| <b>Consultation Response from KC,<br/>Highways Development Management</b>                                                                                         |                                            |                                   |
| <b>2022/90097 adj, 136, Laund Road, Salendine Nook, Huddersfield, HD3 3TY</b>                                                                                     |                                            |                                   |
| <b>Reserved matters application pursuant to outline permission 2021/93779 for erection of residential development with parking and private landscaped gardens</b> |                                            |                                   |
| <b>Date Responded:<br/>03/02/2022</b>                                                                                                                             | <b>Responding Officer: Zack<br/>Turner</b> | <b>Responding Ref: K2-13SW/21</b> |

Client	Naveed Ashraf	Issued From	
Project	2245: 136 Laund Road : Reserve Matters	Date	December 2021
Title	Proposed Plans and Elevations	Scale	1:100 @ A1
Drawn	BH	Auth	BH
Drawing Number	2245 - D - 20 - 110	Revision	A

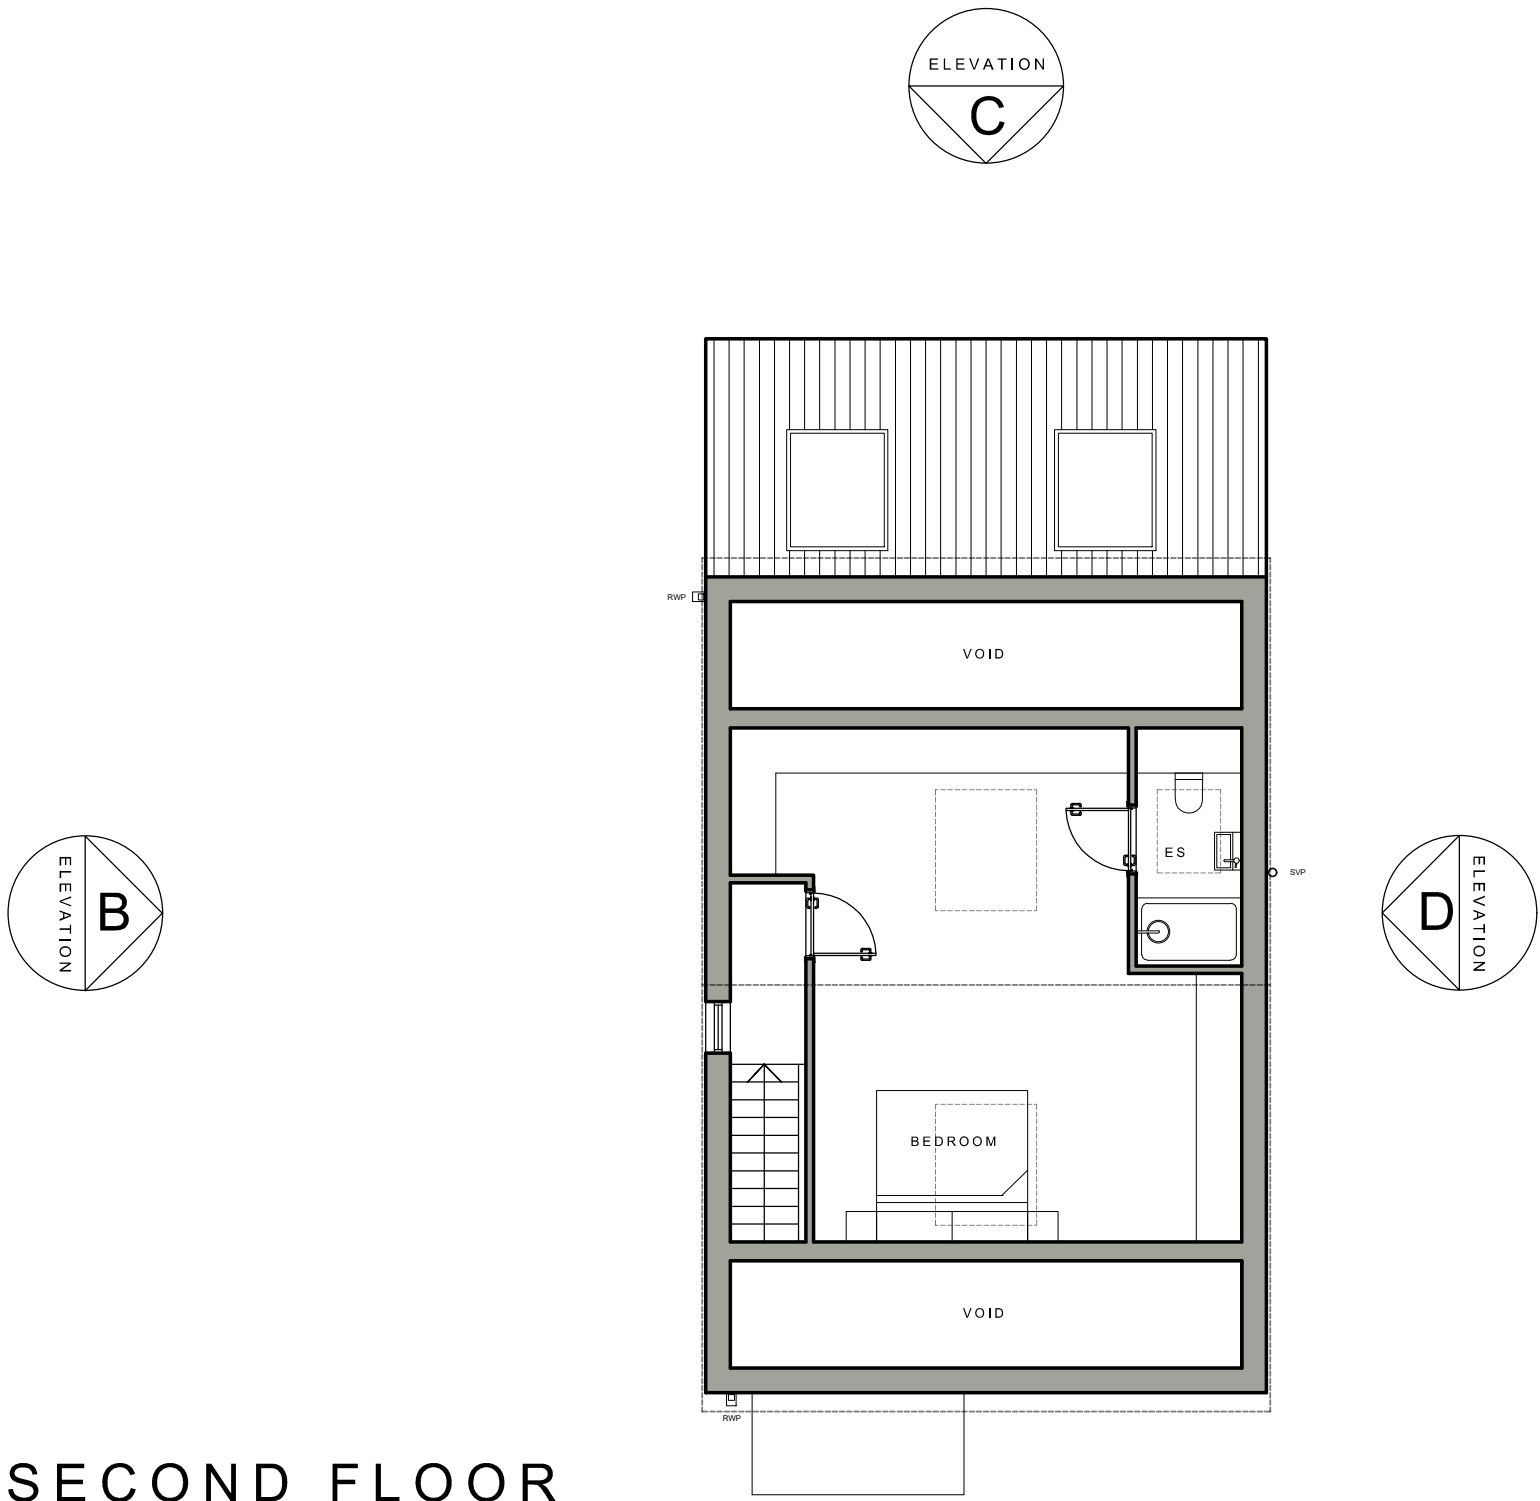
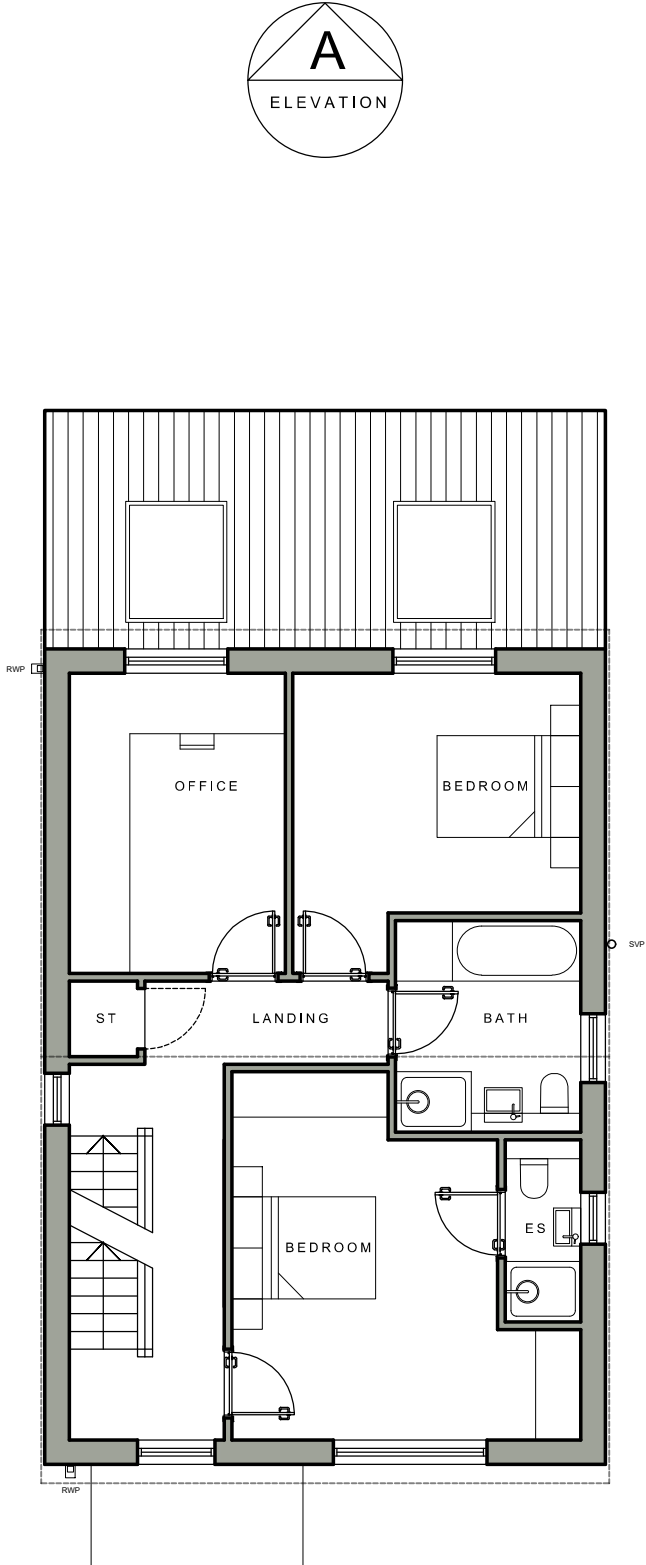
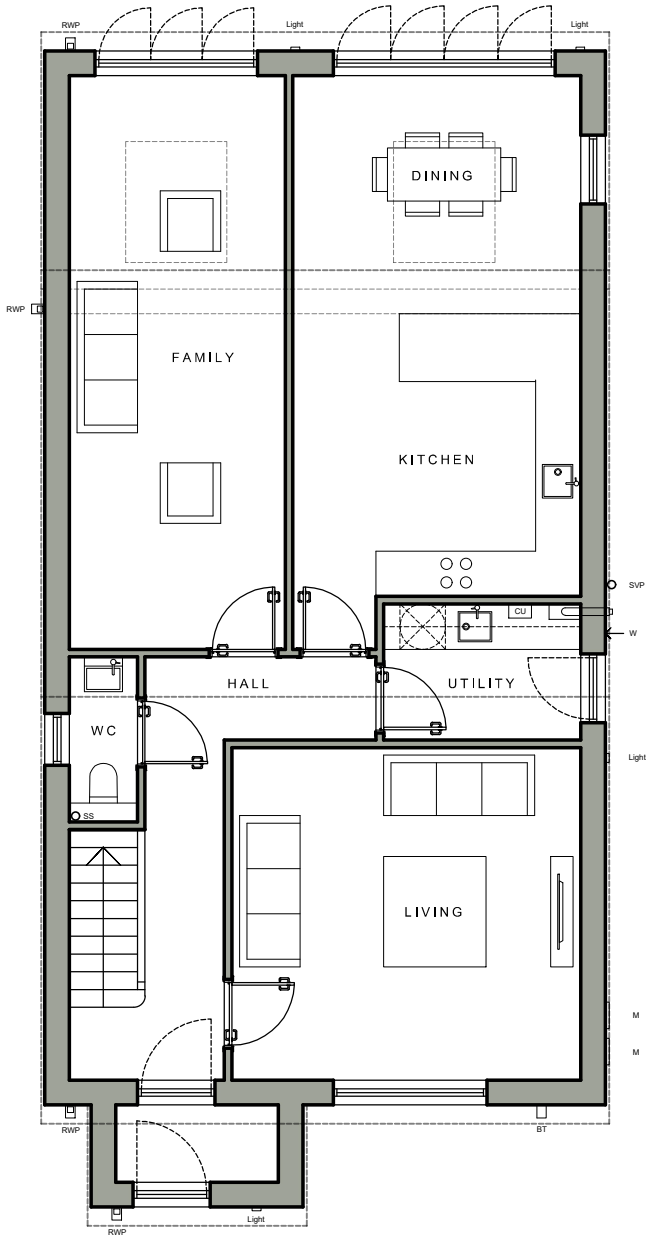
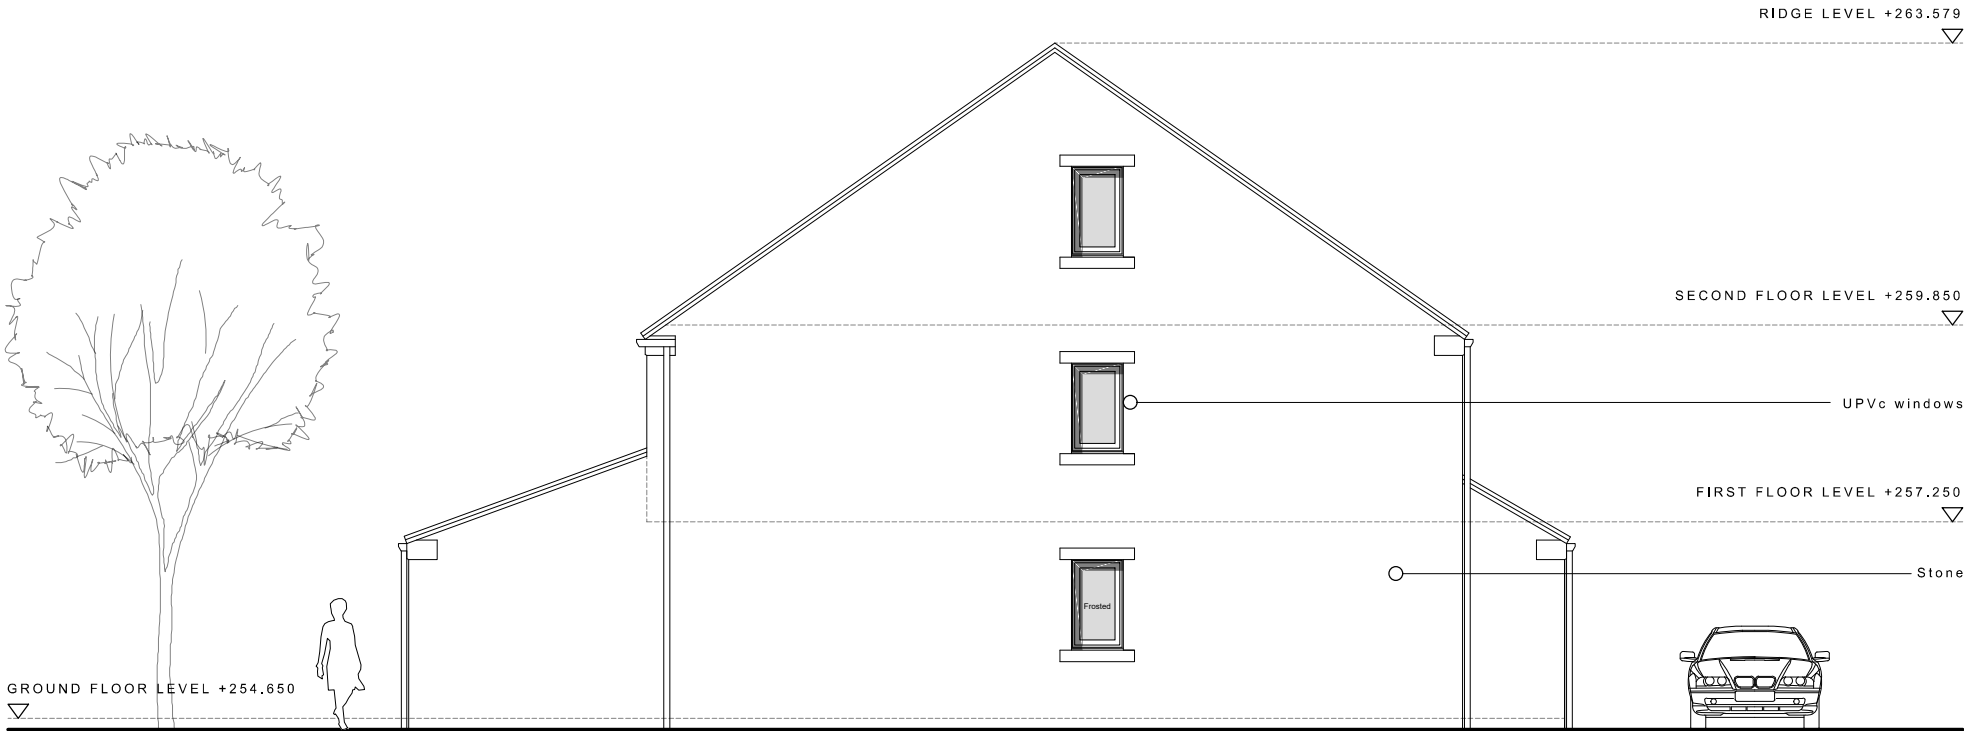
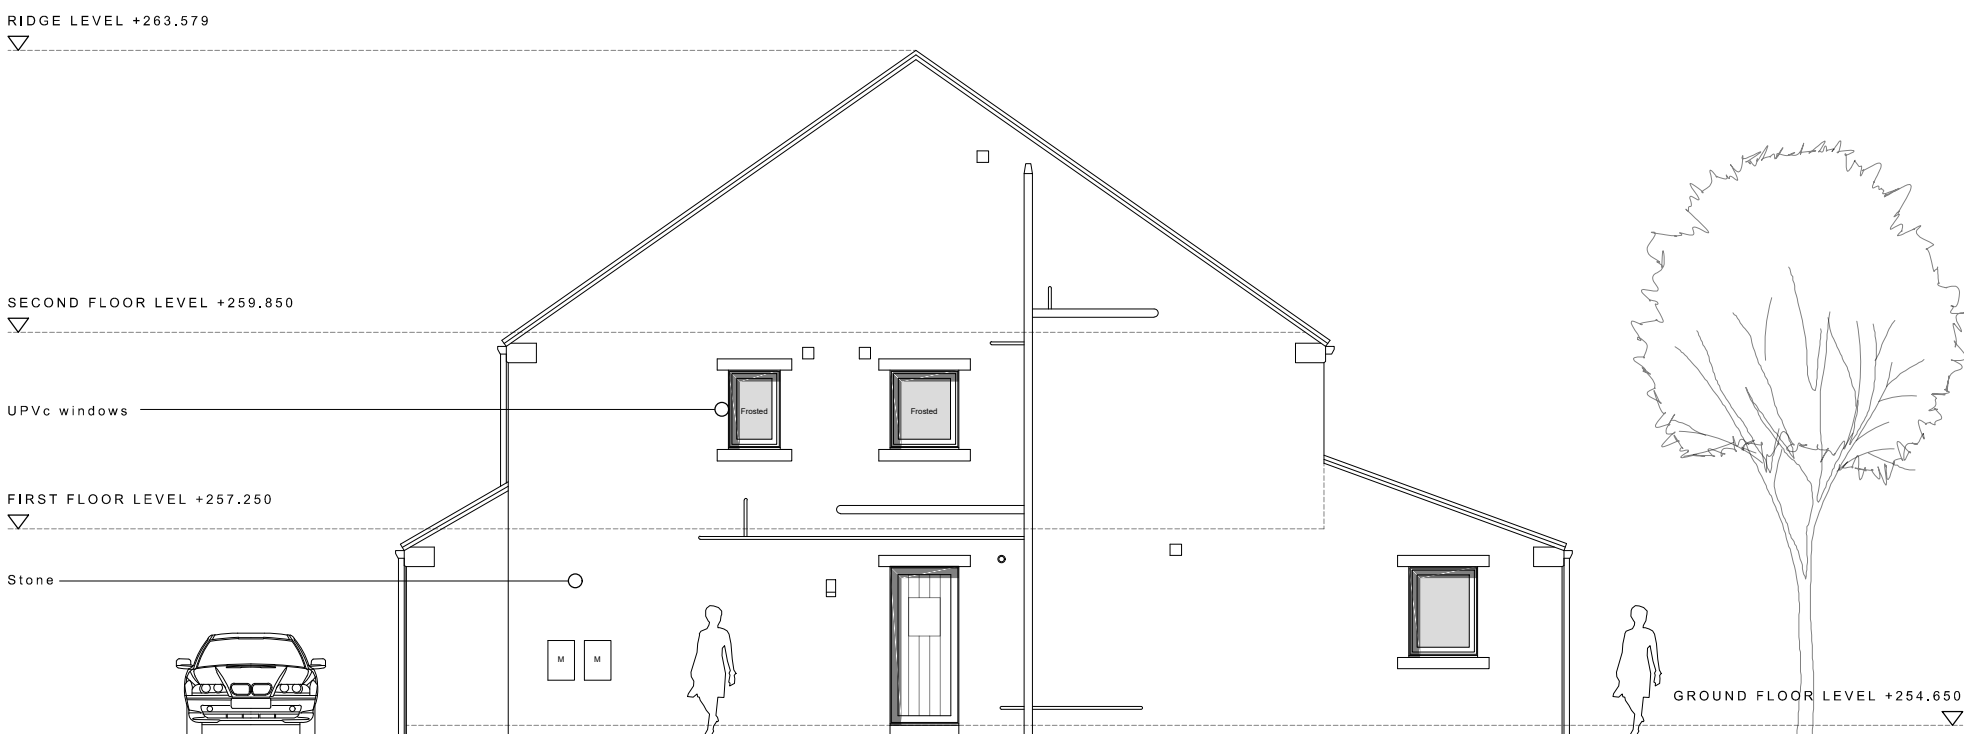
On drawing number 2245-D-20-110 revision A, a room that could be utilized as a bedroom is shown as an office space so in future if it were to be sold as a bedroom an increase in parking provision to 3 spaces would be needed.
